Addendum to J. Wyndham Prince - Basin 6, Hoxton Park Basin Performance & Channel Options Report (6th May 2010)

Prepared on behalf of Mirvac Projects Pty. Limited

October 2010

6. RESPONSES TO RTA/M7 REVIEW COMMENTS ON BASIN PROPOSALS

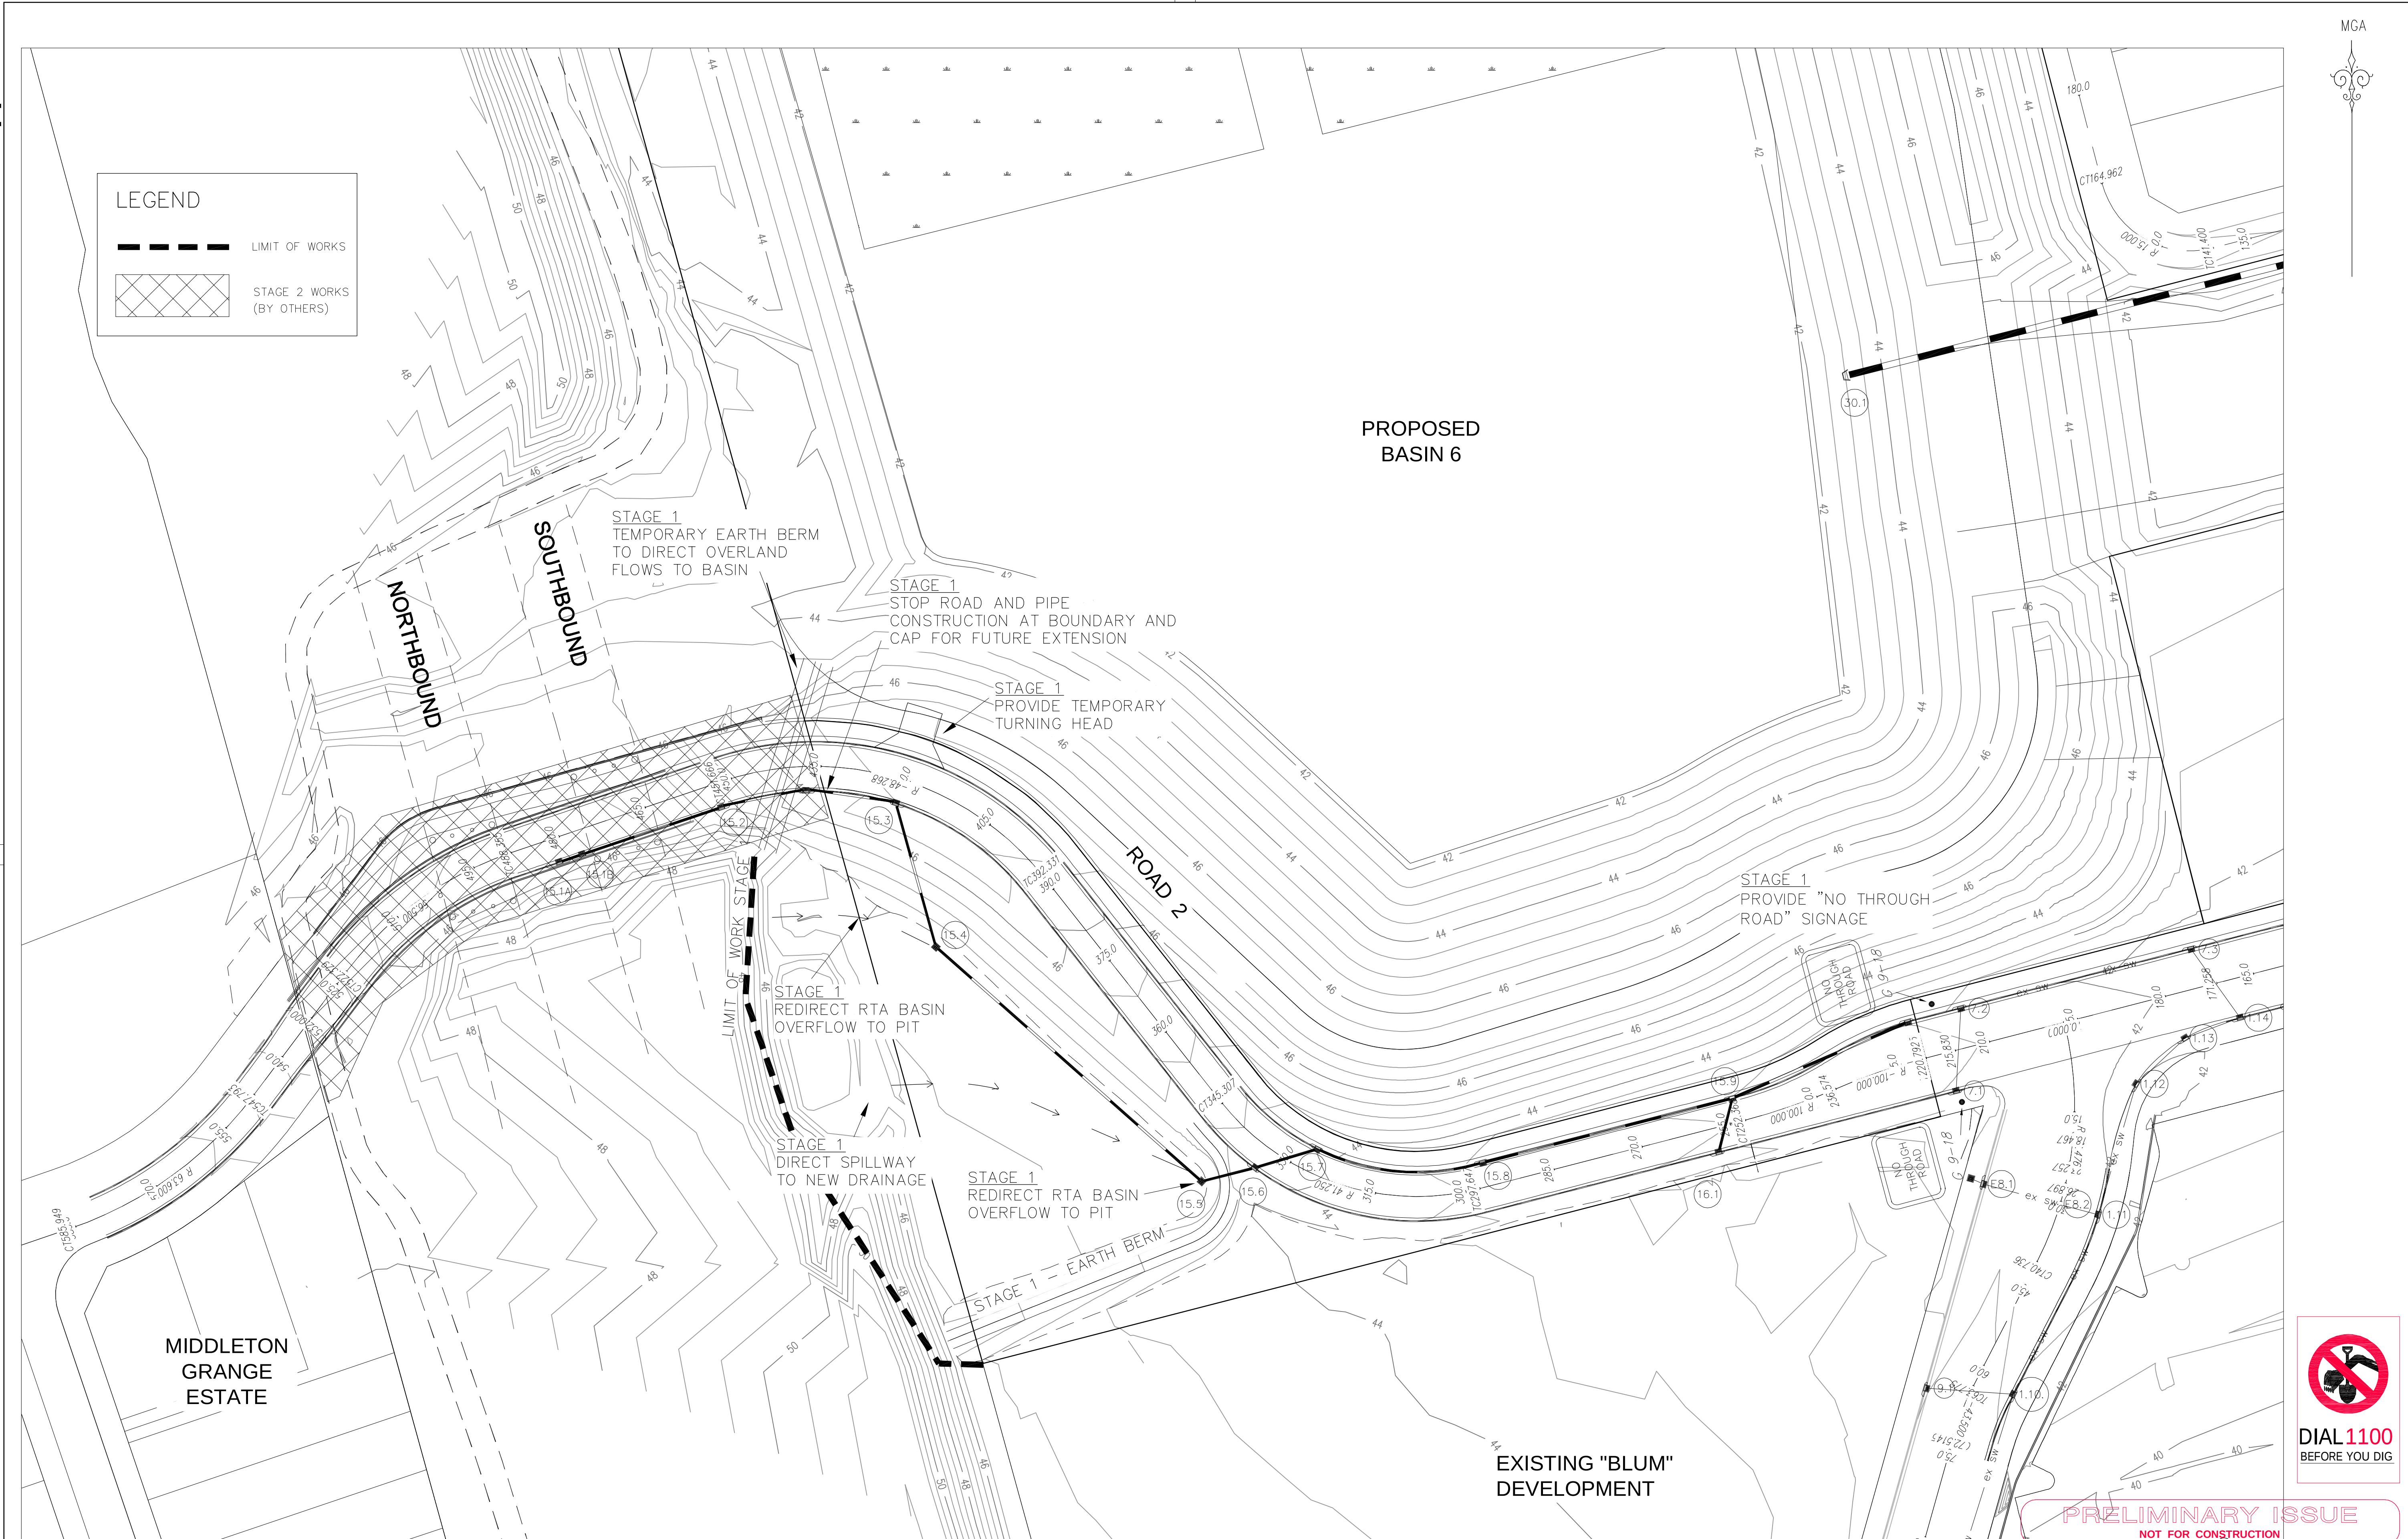
The RTA/M7 require that the works be staged in such a manner that the stage 1 construction can be self sufficient in the event council abandons the connection of the proposed works across the M7 corridor. A construction staging plan has been developed and is shown in drawing 150136-S75W-027. Stage 1 works include;

- Construction of road pavement from the existing construction to support the former Hoxton Park airport redevelopment to the eastern boundary of the M7 corridor
- Construction of a temporary turning head near the end of the stage 1 roadworks
- Construction of the stormwater drainage line to the eastern boundary of the M7 corridor where it will be capped for future extension
- Construction of an earth berm to direct any overland flows around the proposed roadworks and into Basin 6
- Construction of the required services across the M7 corridor linking Middleton Grange with the future residential development to the north of proposed Basin 6. These services are to be installed at a depth consistent with the future extension of the roadworks across the M7 corridor to be undertaken by Council.
